Our ref: NO/2012/103394/01-L01
Your ref: 3/2012/0137
Date: 22 March 2012

**CONSTRUCTION OF NEW 100 COW CUBICLE HOUSE AND ASSORTED
YARDS/ROADS AND SLURRY LAGOON
FISHES AND PEGGY HILL FARM, HENTHORN ROAD, CLITHEROE**

We OBJECT to the proposed development as submitted on the following grounds:-

Earth Banked Slurry Lagoon- Elevations (C484-5)

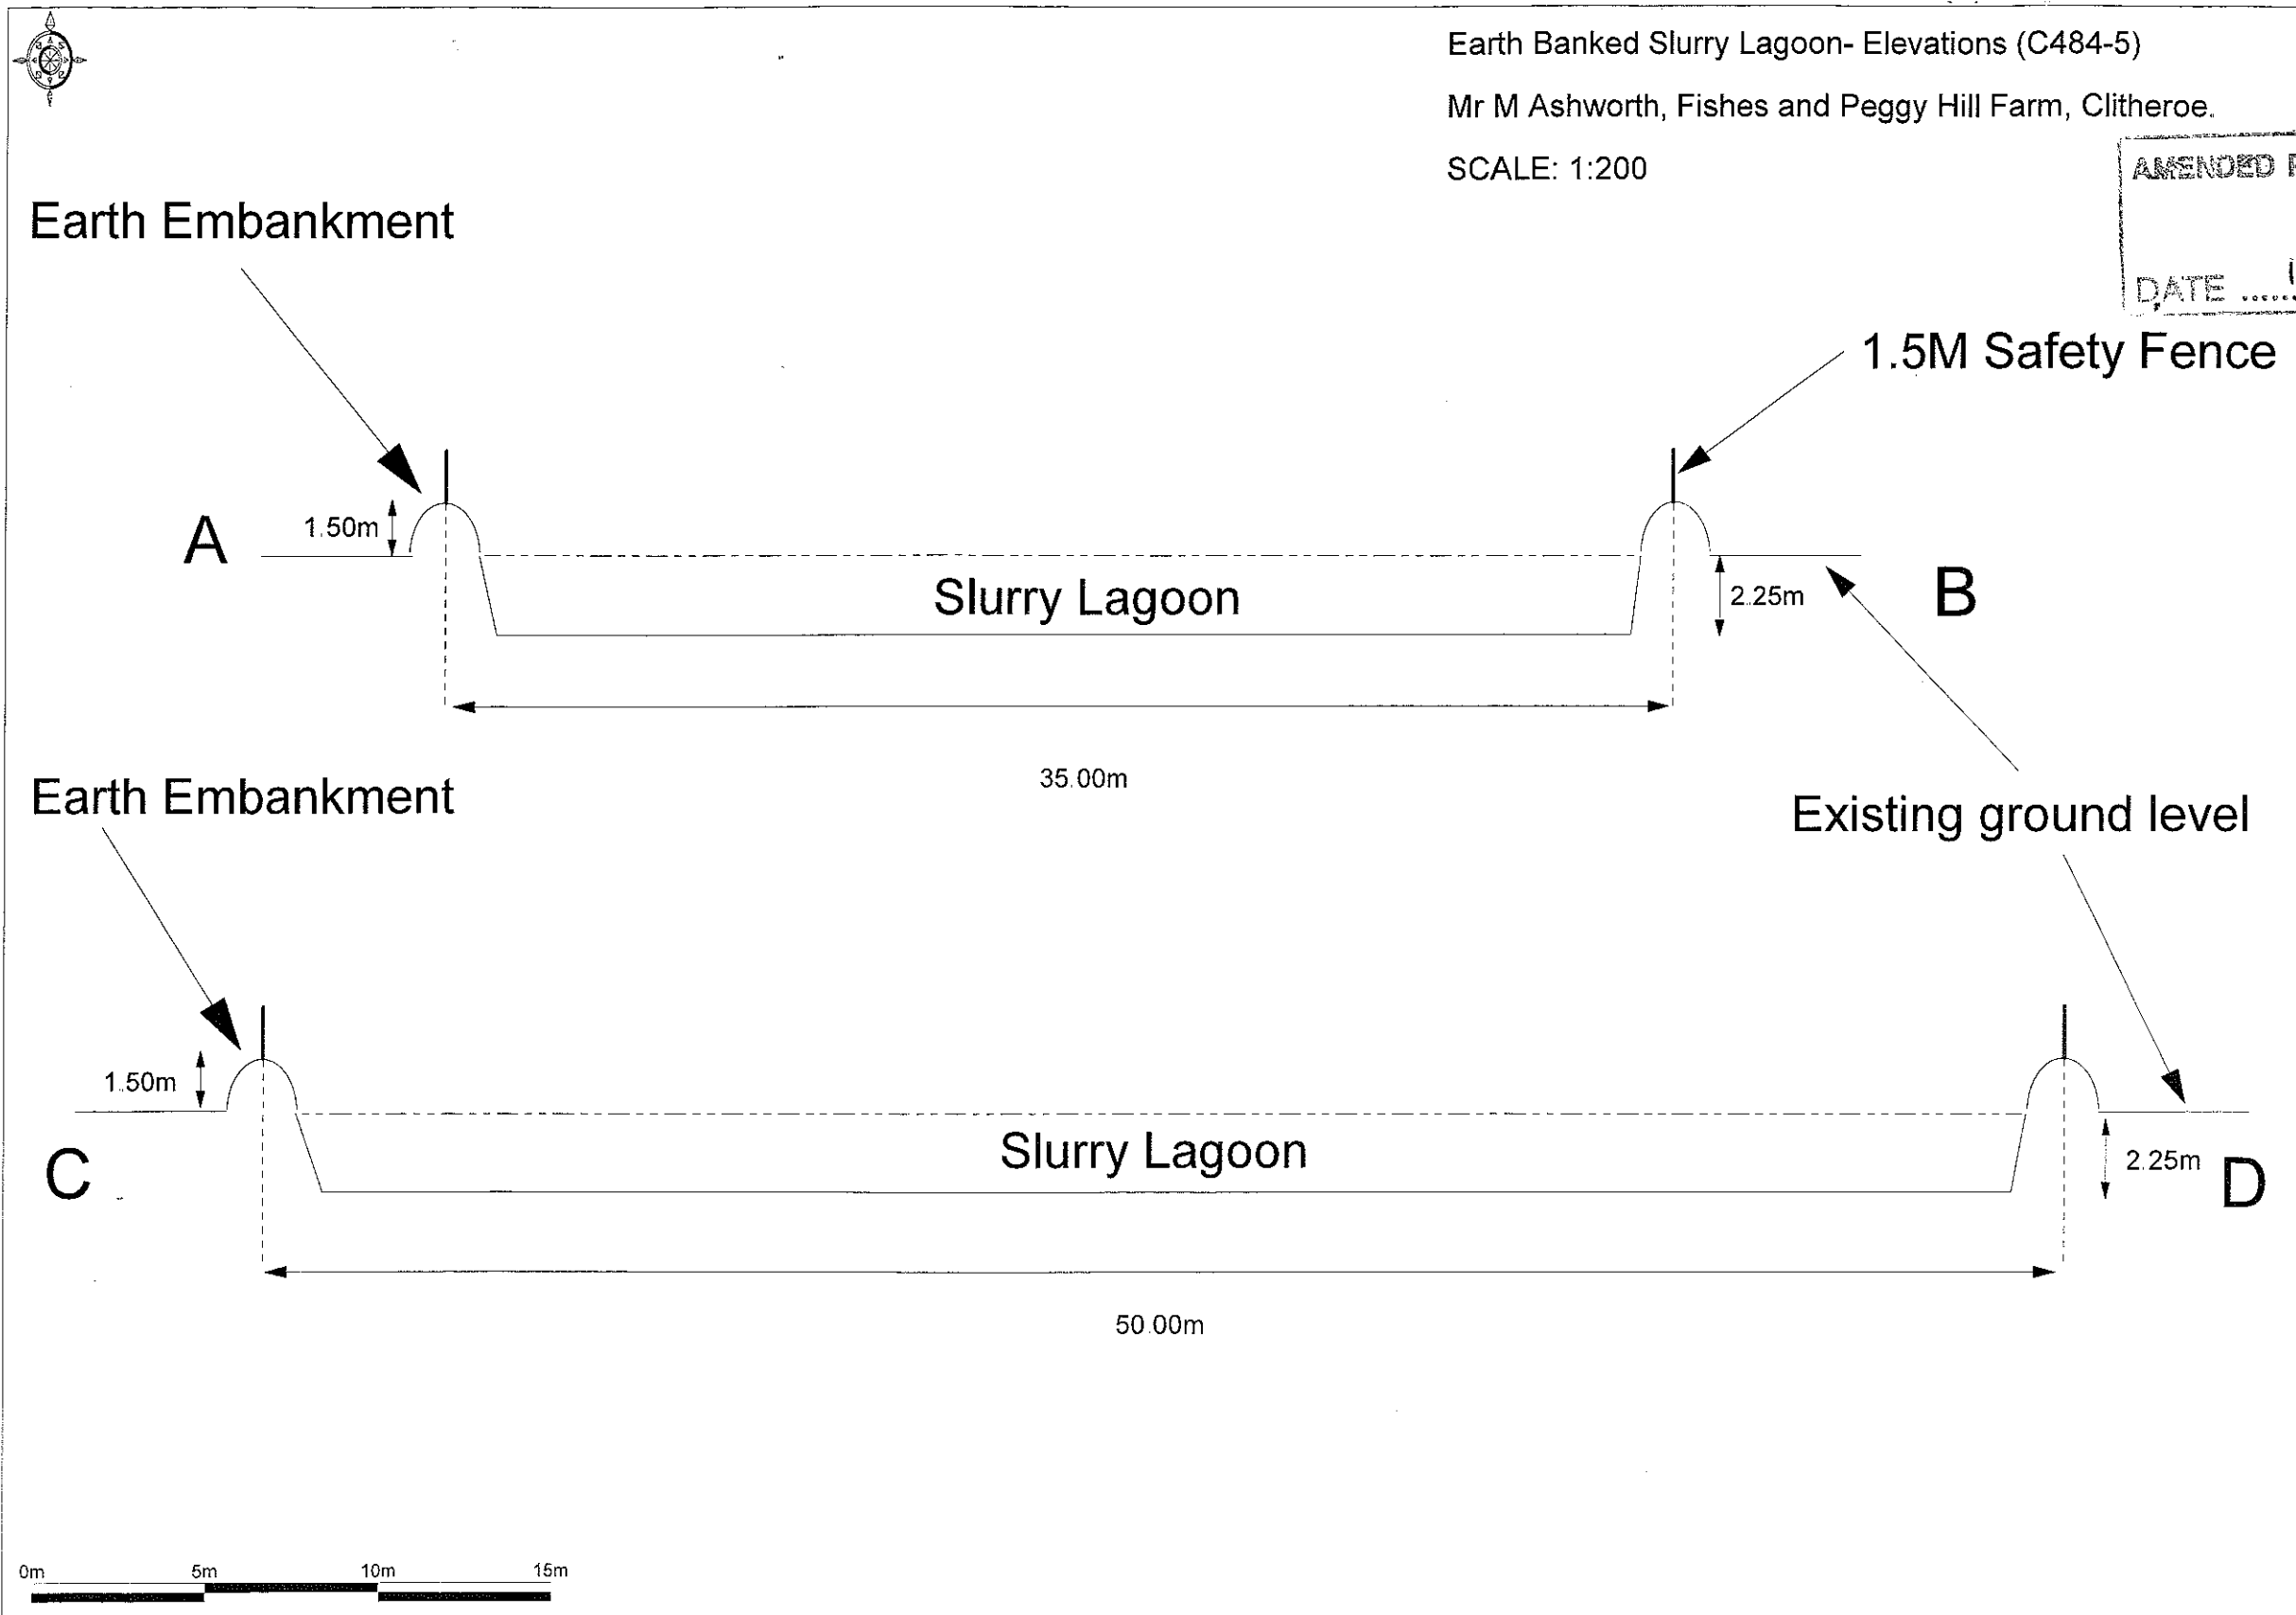
Insufficient information has been submitted in relation to the proposed location of the new slurry lagoon. The applicant needs to demonstrate that 1 metre of material with a suitable permeability will be present beneath the unlined lagoon. The suitability of the location for the proposed lagoon should be demonstrated based on soil tests via trial pits to determine permeability and clay content. These should have been carried out but no details have been submitted to demonstrate this.

The proposed development must fully comply with the terms of The Water Resources (Control of Pollution) (Silage, Slurry and Agricultural Fuel Oil) (England) Regulations 2010 and The Code of Good Agricultural Practice (COGAP) for the protection of water, soil and air (produced by DEFRA). There is no information provided with the application to demonstrate that the proposed structure will comply with the SSAFO Regulations 2010.

If the applicant submits details to demonstrate that the ground conditions are suitable and how the proposed structure will comply with the SSAFO Regulations 2010, we will be able to review our objection.
